From: [Rich Elliott](#)
To: [Chace Pedersen](#)
Cc: [Dan Young](#); [Joe Delvo](#); [Dan Johnson](#)
Subject: RE: [Ext] ACU-23-00003 Atlas - Notice of Application
Date: Tuesday, August 8, 2023 9:15:44 AM

KVFR is not the AHJ for fire codes. Our list below focuses on the operational impacts. KCFMO will comment on the fire code more comprehensively.

CDS is requesting comments on the following Administrative Conditional Use application: ACU-23-00003 Atlas

SHEET TITLE:
SITE PLAN

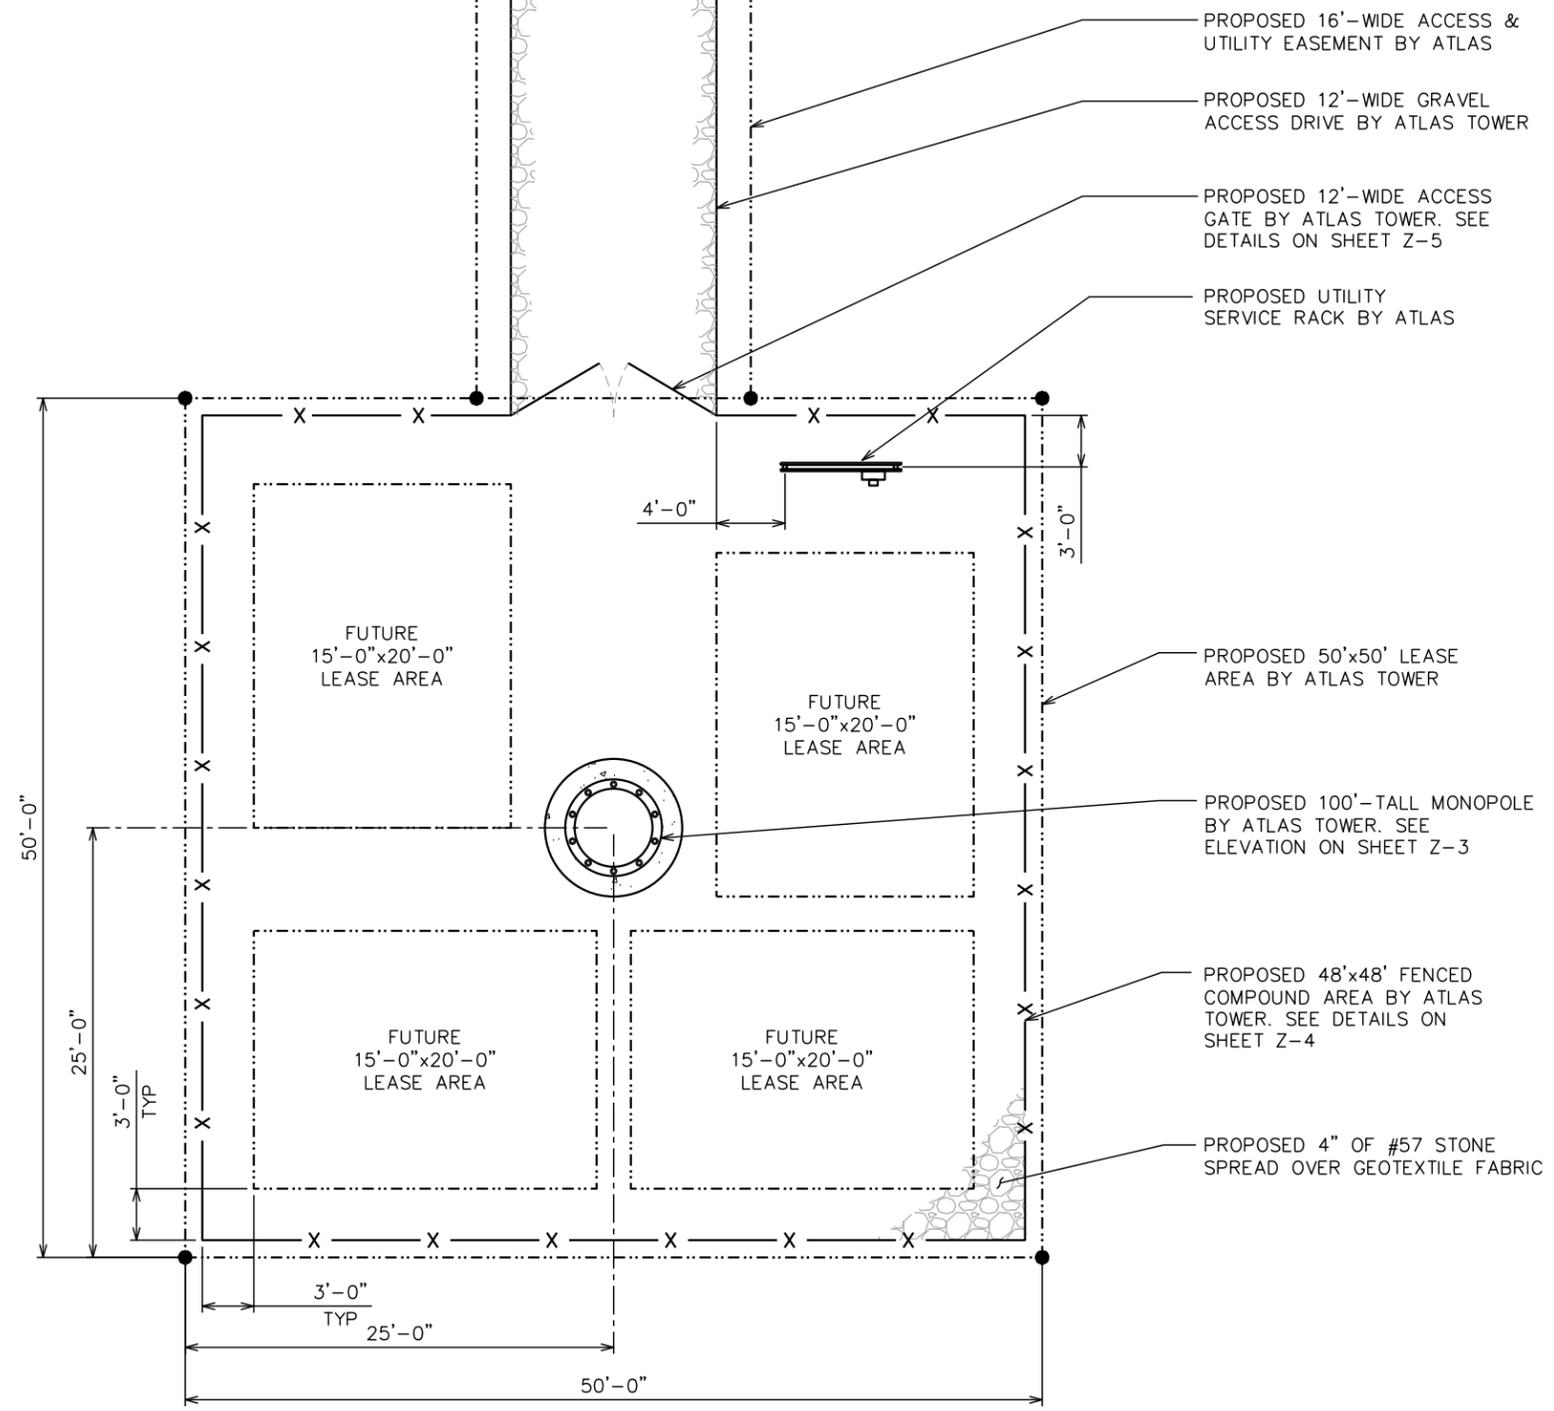
- Addressing for facility must be visible from both directions of travel on Manastash.
- Access road, including turn-around will need to be Appendix D compliant.
- A KVFR Knox lock/box will have to be installed to provide access for KVFR.
- Strongly encourage fire resilient landscaping.
